List of Drawing Amendments for Issue to DoP

Date: 03 June 2010

DWG No.
 EA101

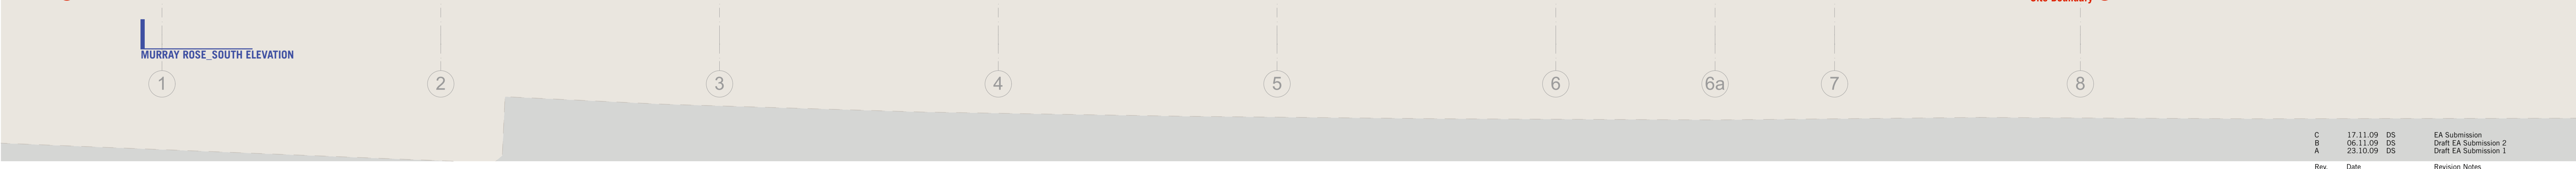
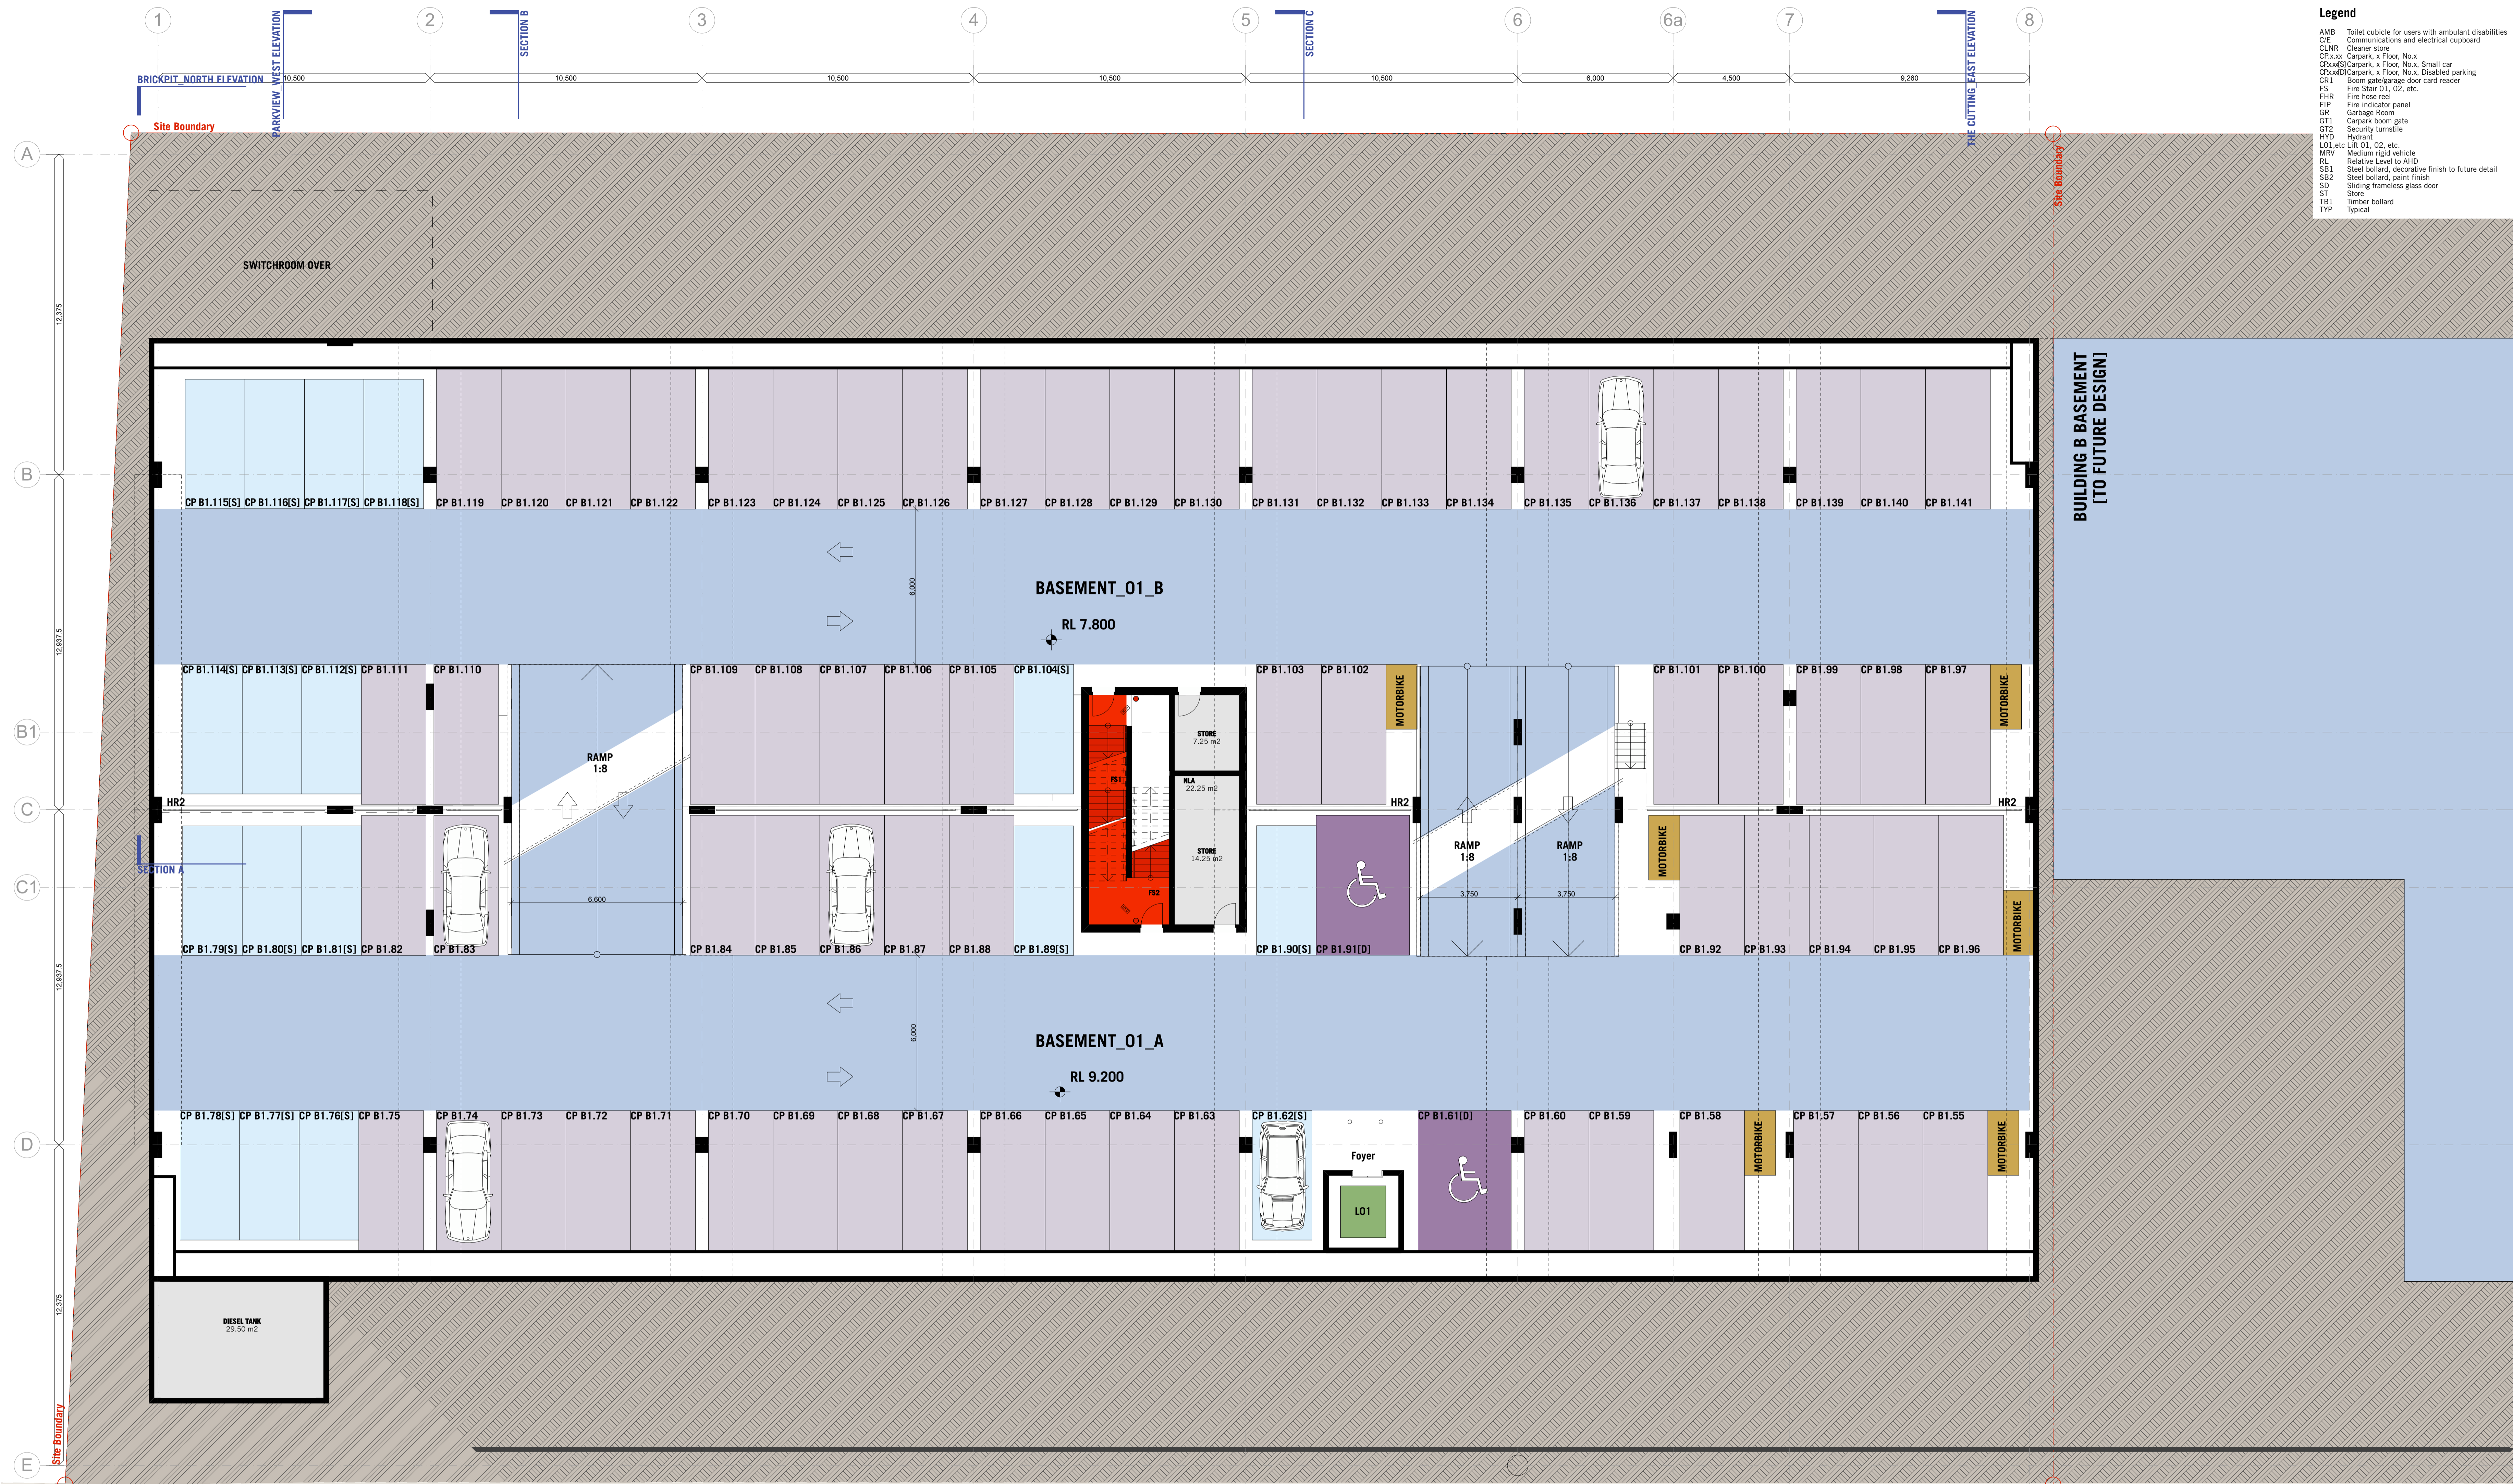
EA 101	Basement 01 Plan	E	30 May 2010	1	<ul style="list-style-type: none"> As per EA 100 Sub floor deleted due to depth requirements of road above (previously shared pedestrian / loading dock access)
				2	
EA 102	Ground Floor Plan	G	02 June 2010	1	<ul style="list-style-type: none"> As per EA 100 Car Park roller shutter is amended to cassette type metal cladding with TC1 (timber cladding) deleted. Sliding doors in bike store deleted
				3	
EA 103	Upper Ground Level	G	02 June 2010	4	<ul style="list-style-type: none"> Adjustment to loading dock levels and dock slab extended over fire corridor below Garbage room redesigned to suit 6 Star Green Star requirements Café toilets reconfigured and enlarged Commercial tenancy A_02 enlarged to recover area lost from garbage room expansion, now builds out to café toilets Commercial tenancy A_01 layout altered with storage area now being incorporated into the main floor plate
